1 Coolnahinch,
Dundrum Road,
Dublin 14

Re: Planning Appeal – 1 Coolnahinch, Dundrum Road, Dublin 14 (D26A/0556/WEB)

TITLE
PROPOSED ELEVATIONS

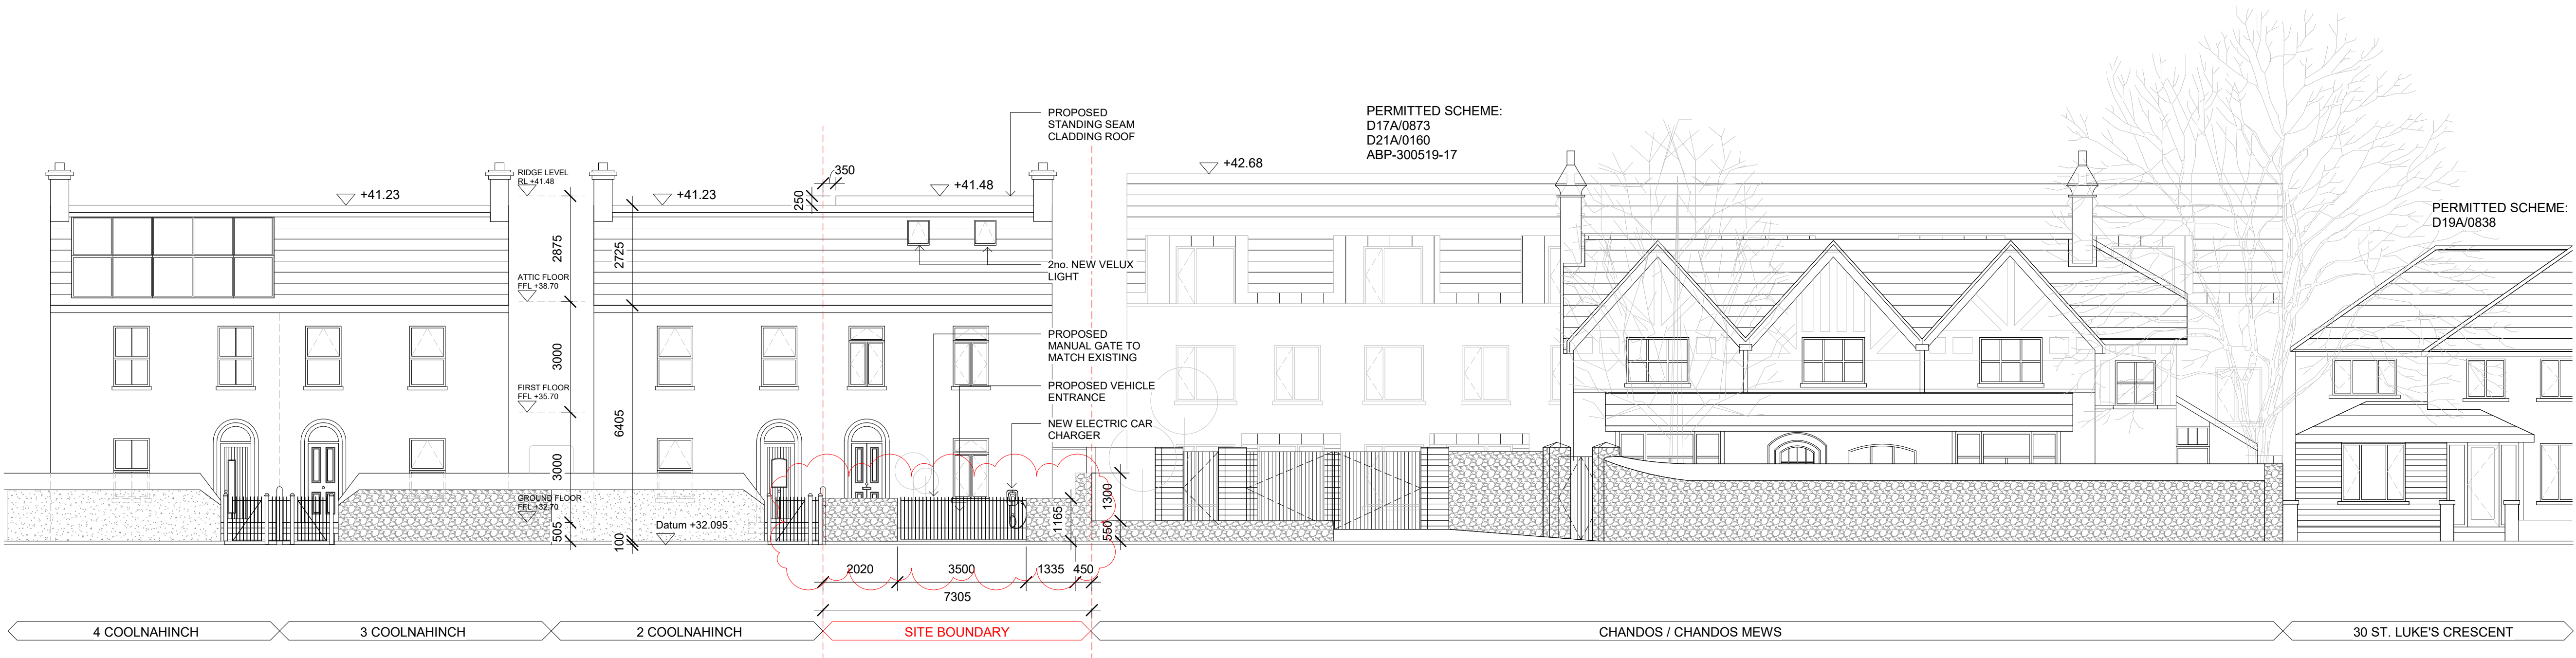
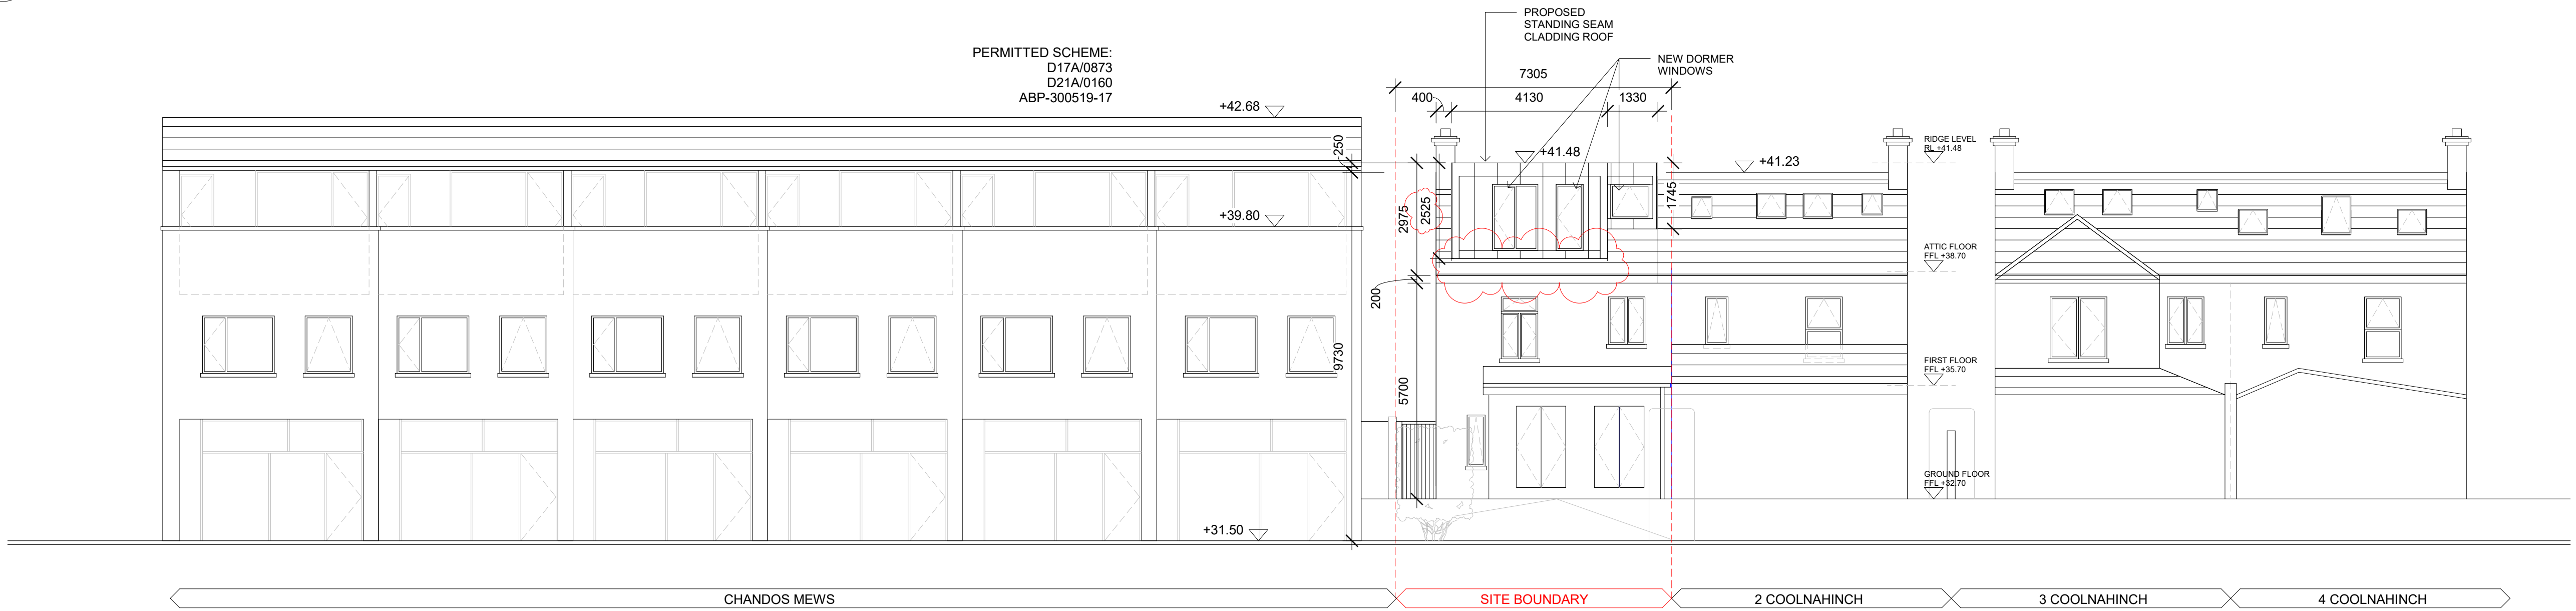
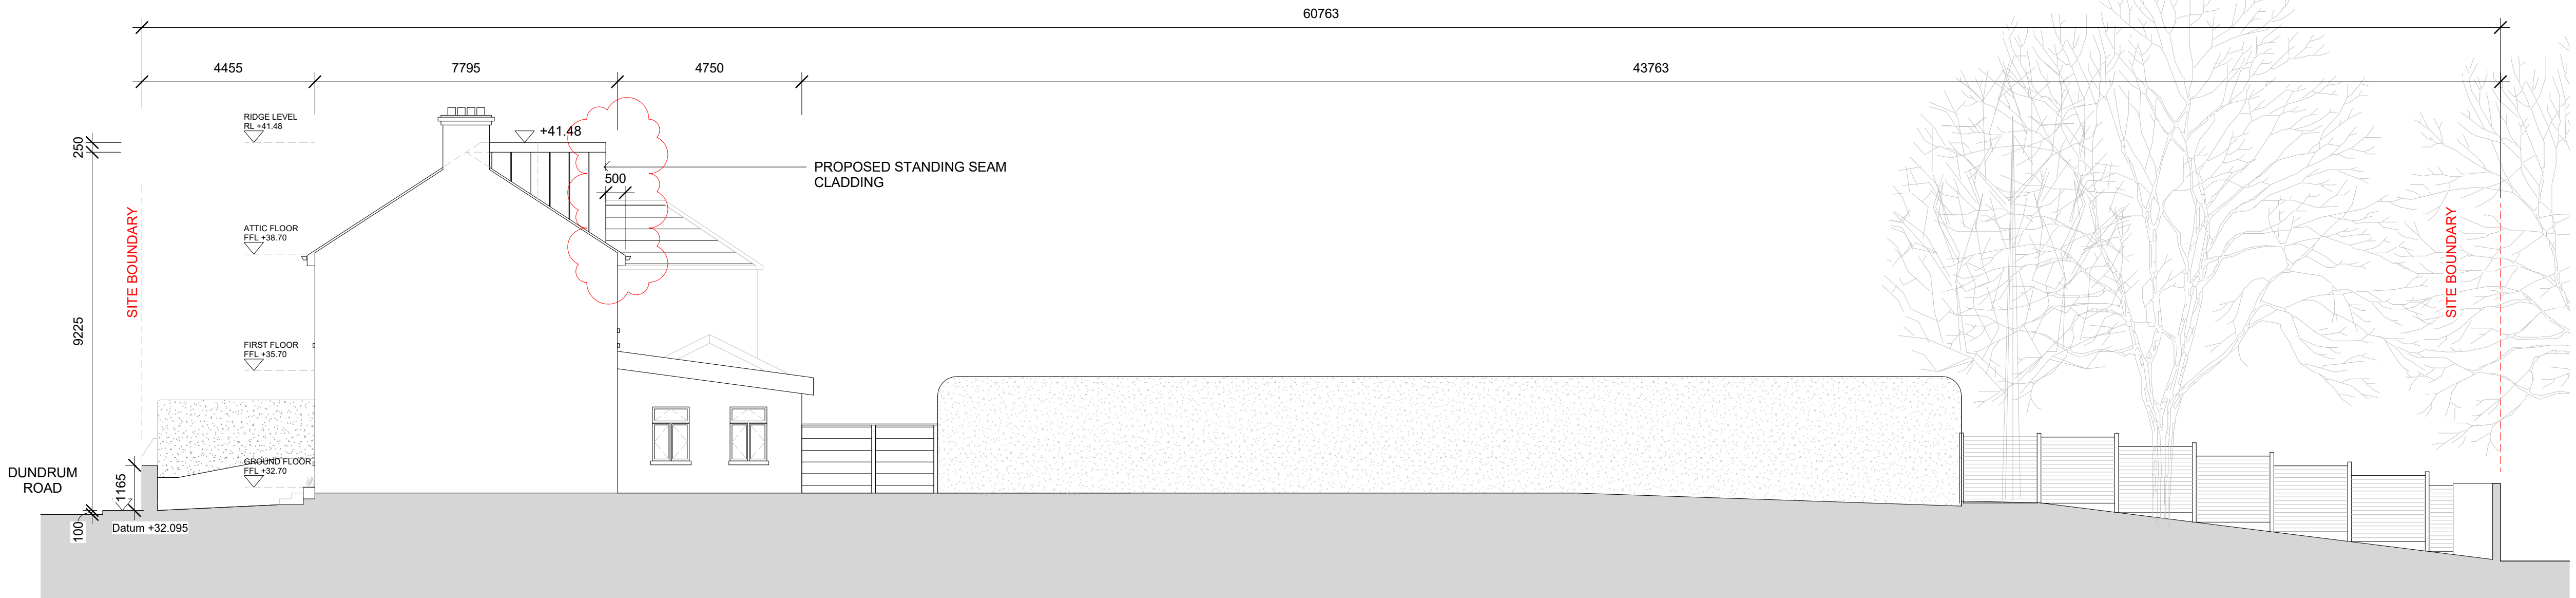
1. Having regard to the scale bulk and massing of the proposed rear dormer, it is considered that the proposed works would be excessive, visually incongruous in the roofscape and would result in significant negative visual impact on the character of the streetscape. Therefore, the proposed development fails to comply with Section 12.3.7.1 Extensions to Dwelling (iv) Alterations at Roof/Attic level of the Dún Laoghaire Rathdown County Development Plan 2022-2028 and would set an undesirable precedent for similar development within the area. The proposed development would therefore be contrary to the proper planning and sustainable development of the area.

“While the proposed 250mm increase in ridge height is not, in itself, considered to materially impact visual amenity, the planning authority remains concerned regarding the scale, bulk and massing of the proposed rear dormer structure. Having regard to its limited set back from the ridge and its overall dominance within the rear roof plane, the proposed dormer would appear visually intrusive and incongruous and would fail to comply with section 12.3.7.1 (iv) Alterations at Roof/Attic Level of the Dun Laoghaire Rathdown County Development Plan 2022-2028.”

In response to this Planning report we have amended dormer extension and set it back from the eaves so the extension can be read as a new entity, and not part of the original building. The massing was originally set back from the neighbouring property and the gable wall.
